**WEST SUSSEX COUNTY COUNCIL
STRATEGIC PLANNING CONSULTATION**

**SUBJECT: BN/29/15/PL - Solar park , Land at Barnham Court, Church Lane, Barnham,
West Sussex.**

**Updated response to CMP submitted by applicant in email on 6th October
2015.**

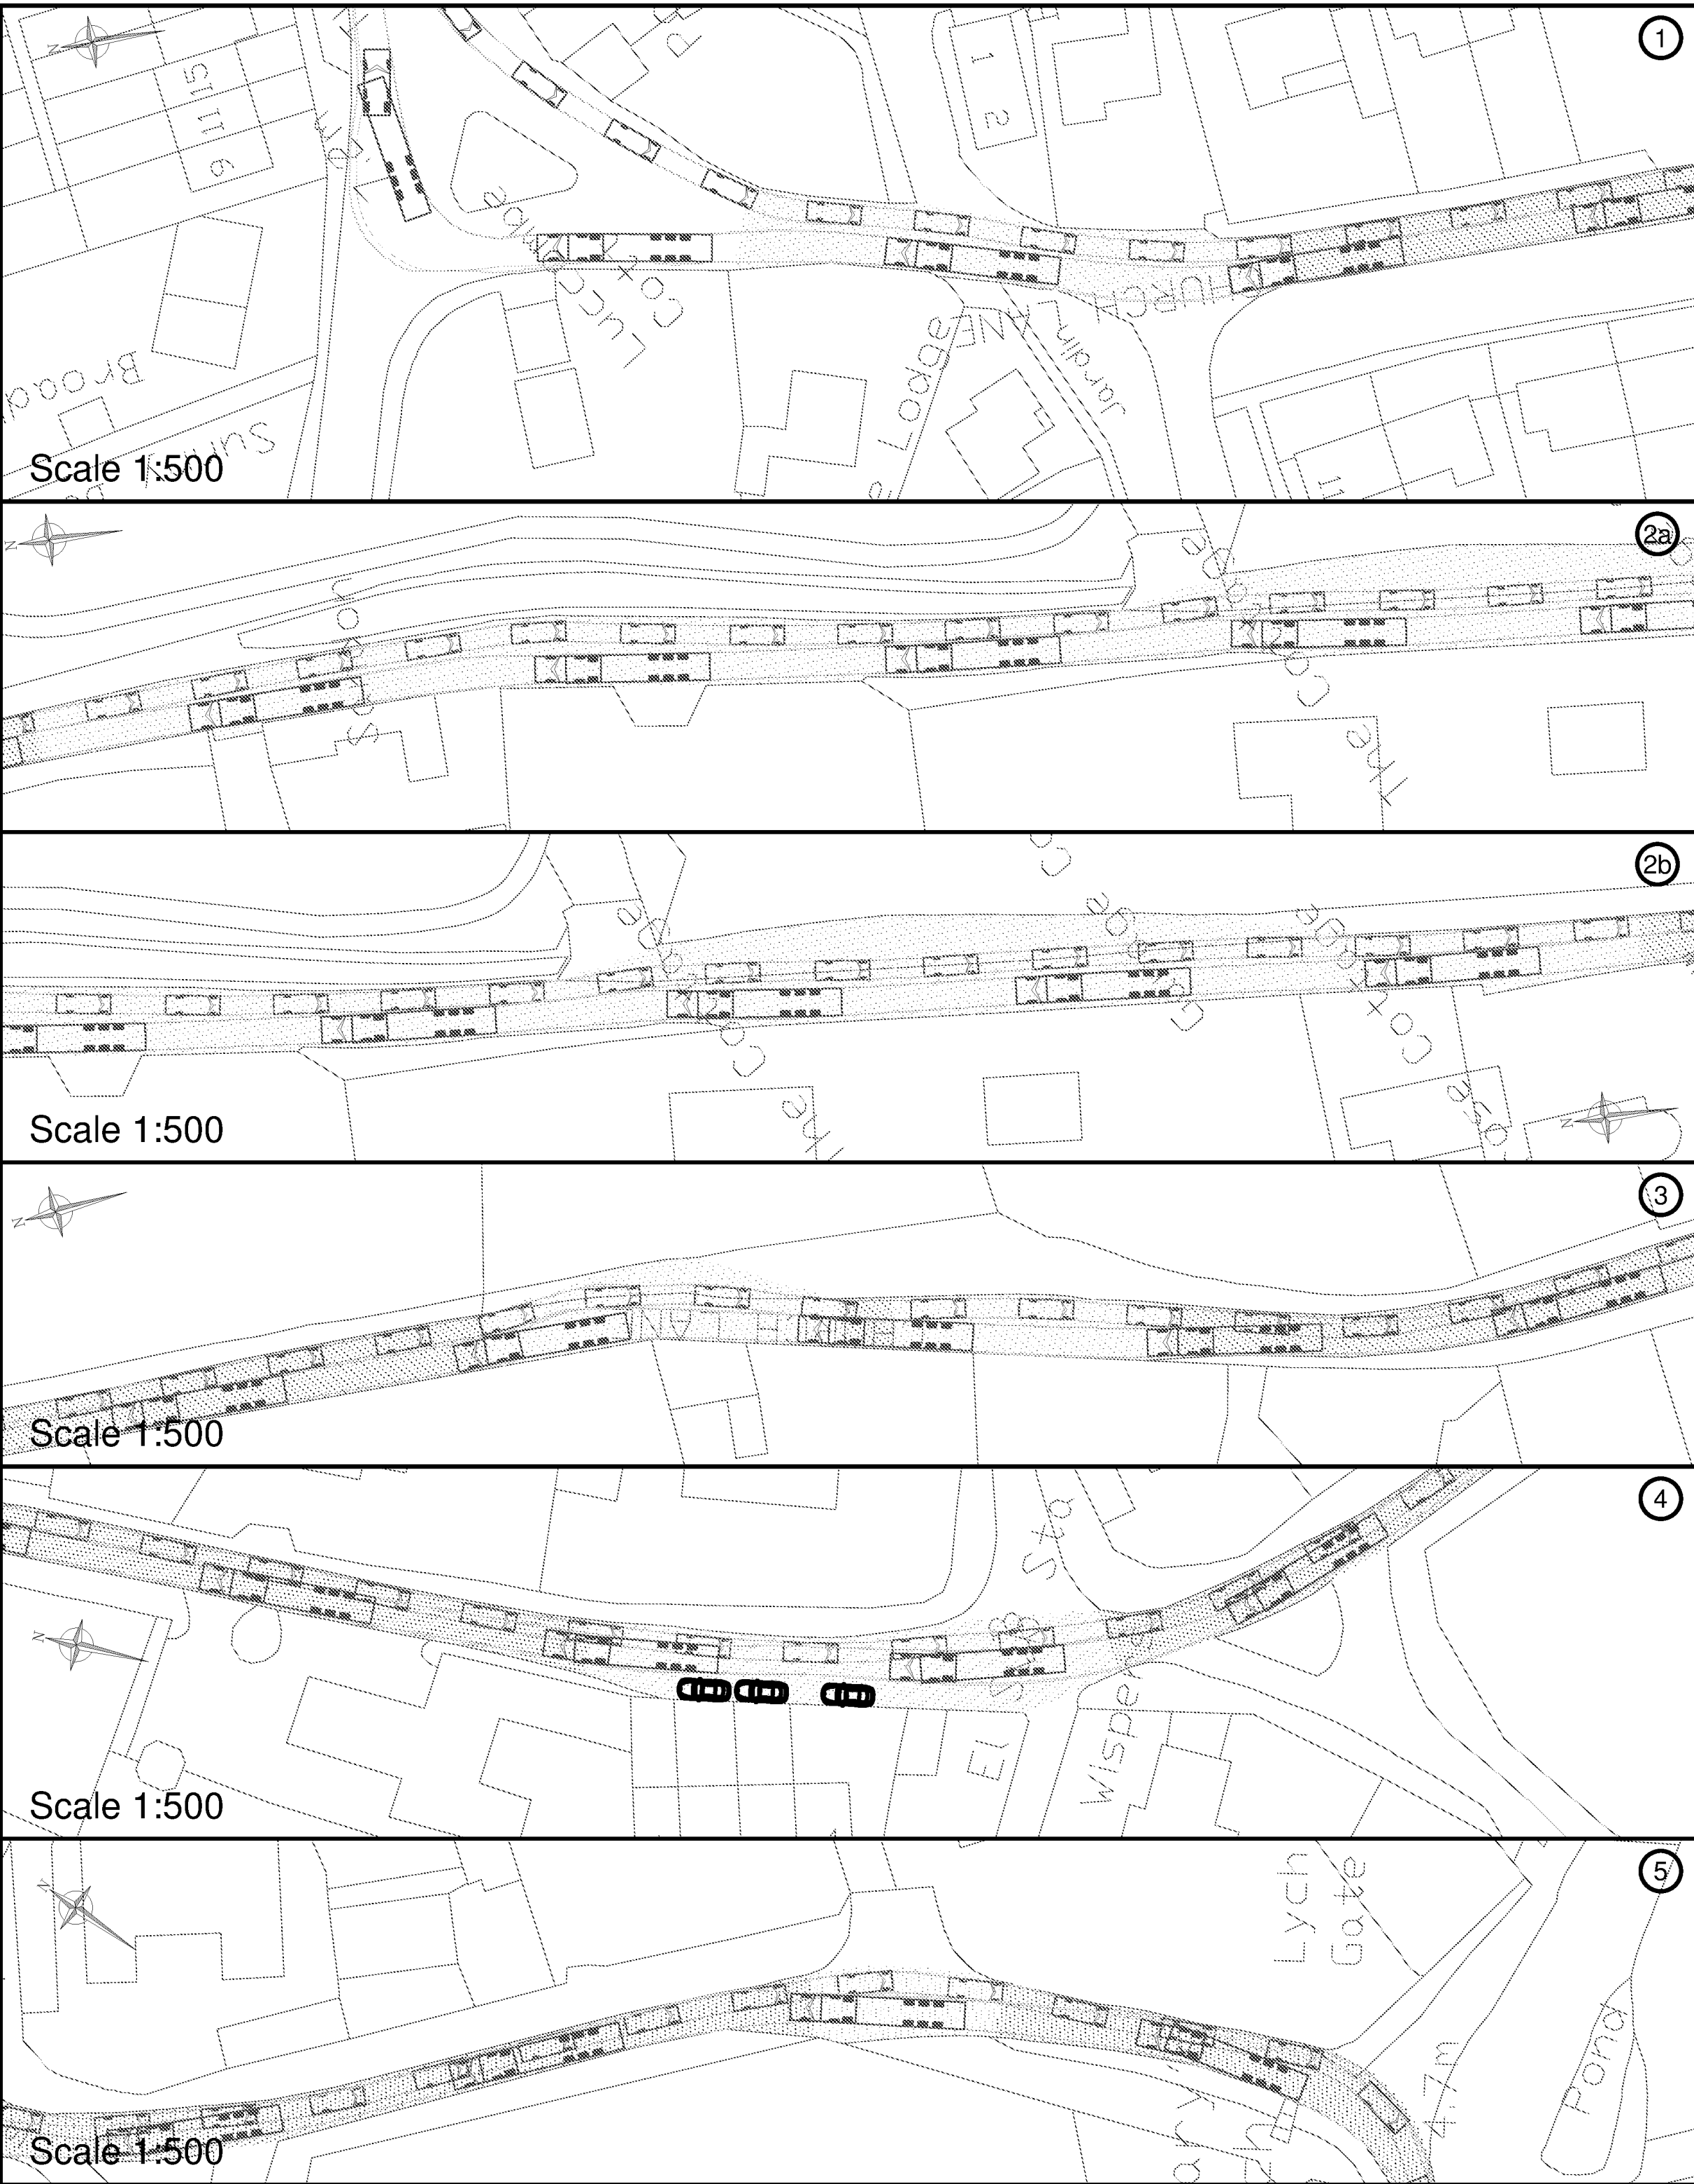
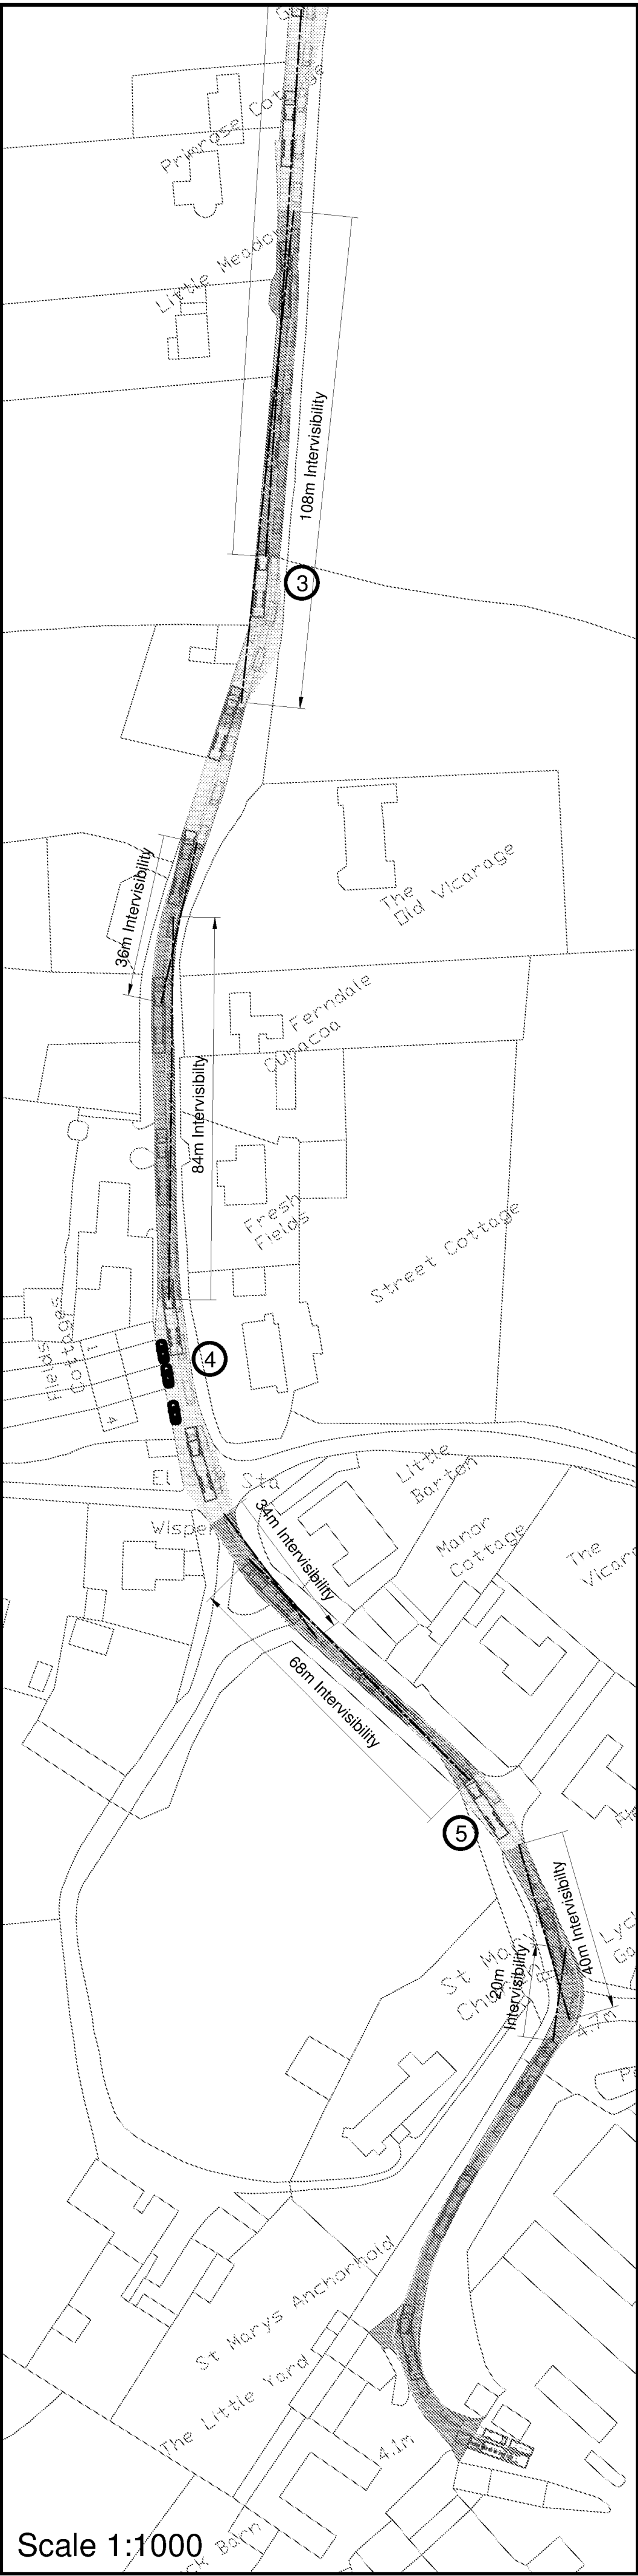
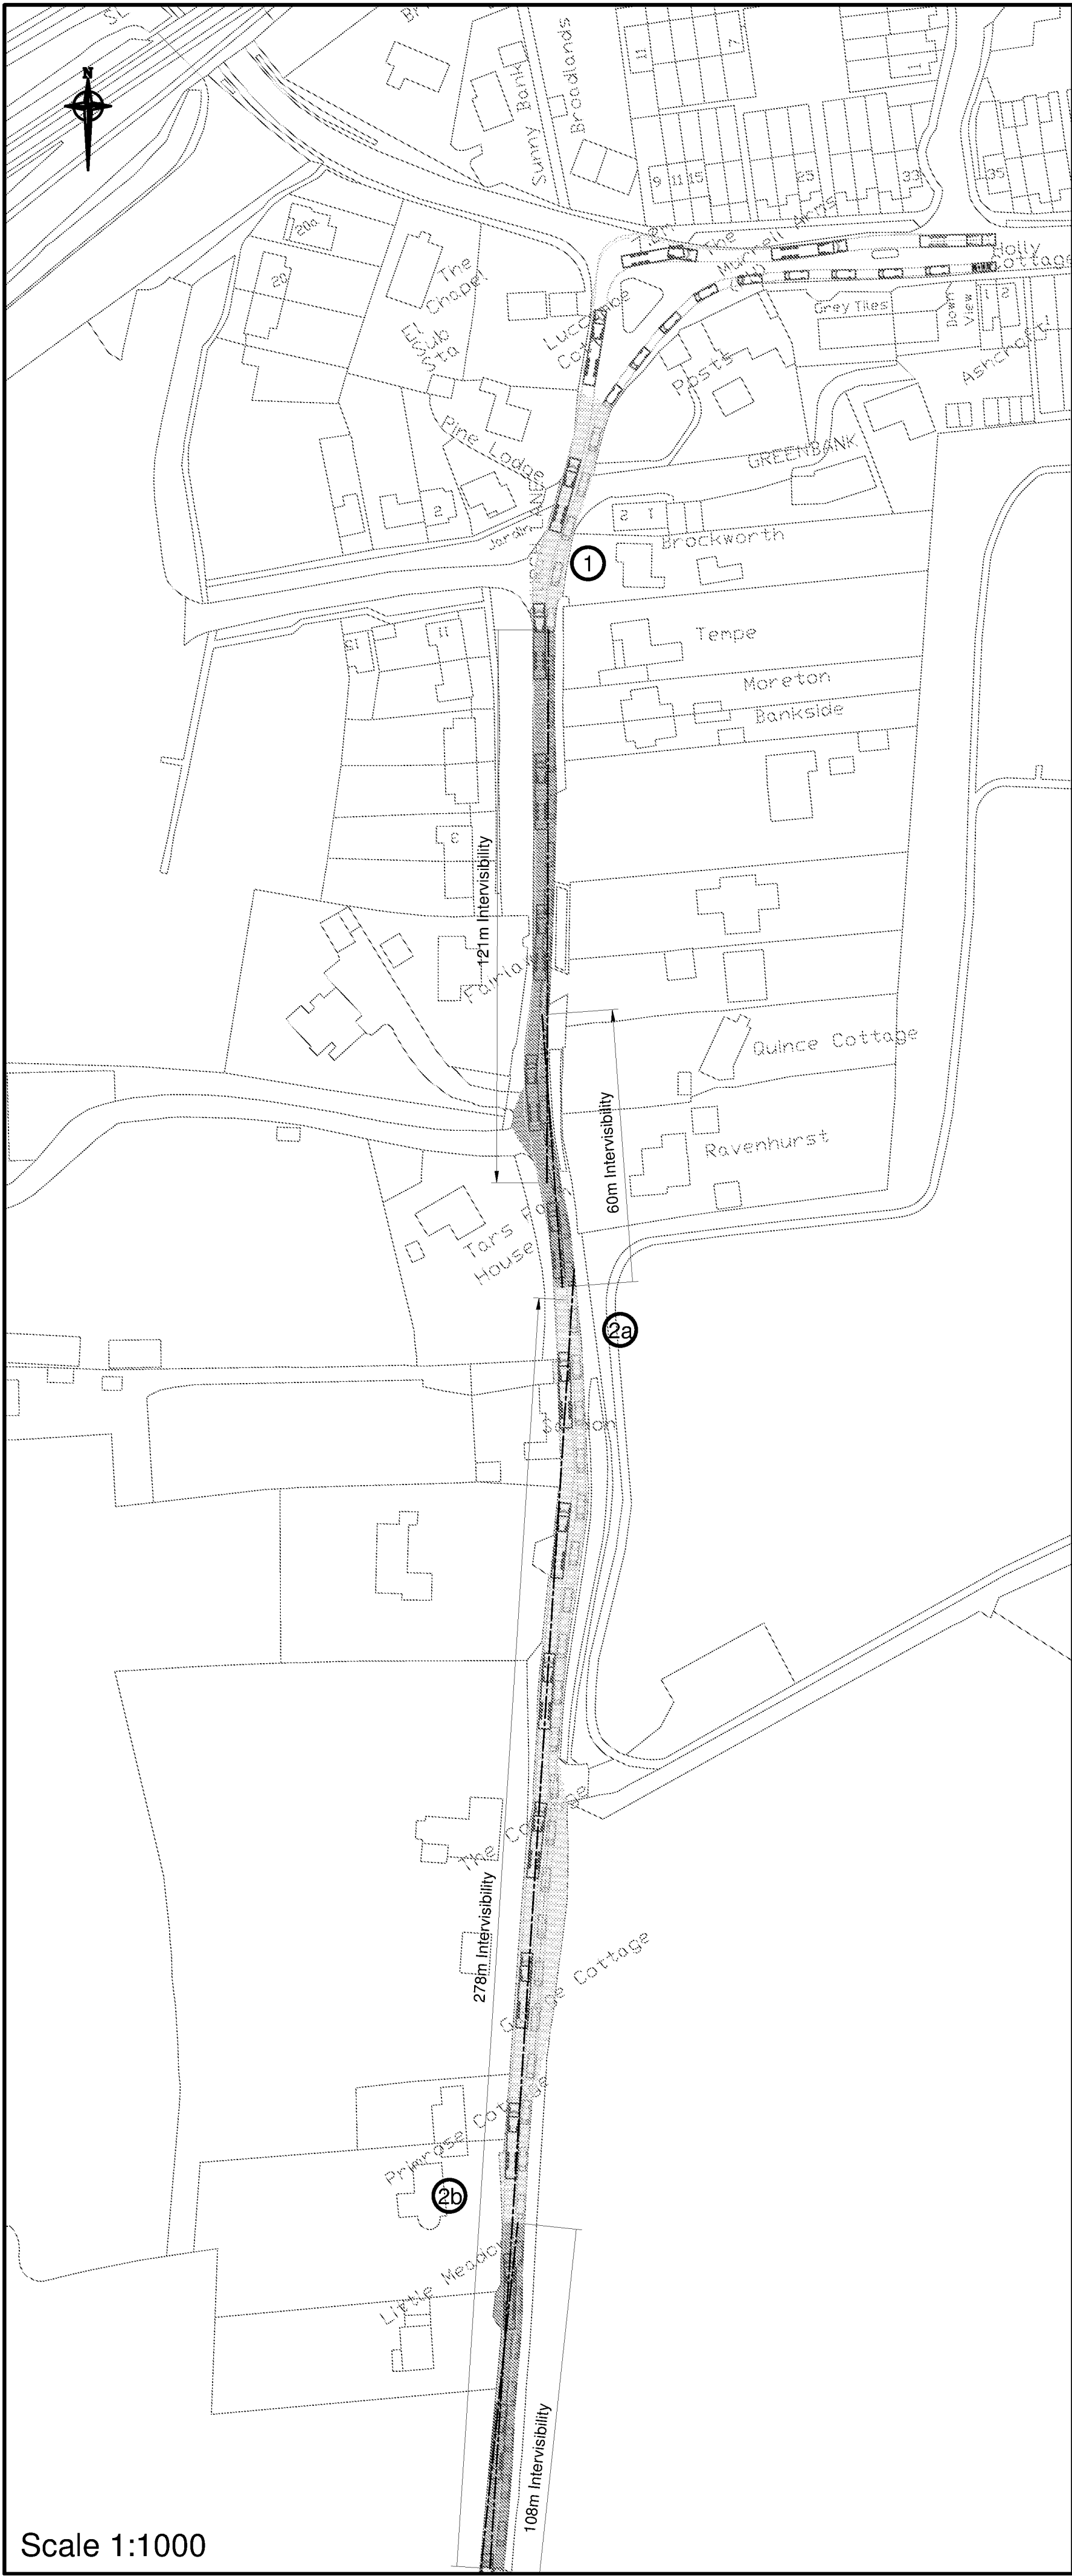
Swept paths provide evidence these can use the junction even with parked cars.

Swept Path diagrams provided for the entire length of Church Lane, indicate where there is good forward visibility, passing places, and also areas which will need management. A package of measures has been proposed to deal with these places which are narrow and cannot accommodate two passing vehicles. These are:-

As mentioned earlier as part of the routing agreement the parking of vehicles at the junction of Church Lane and Yapton Road, might need to be temporarily restricted to ensure the HGV vehicles can make the turn into the lane.
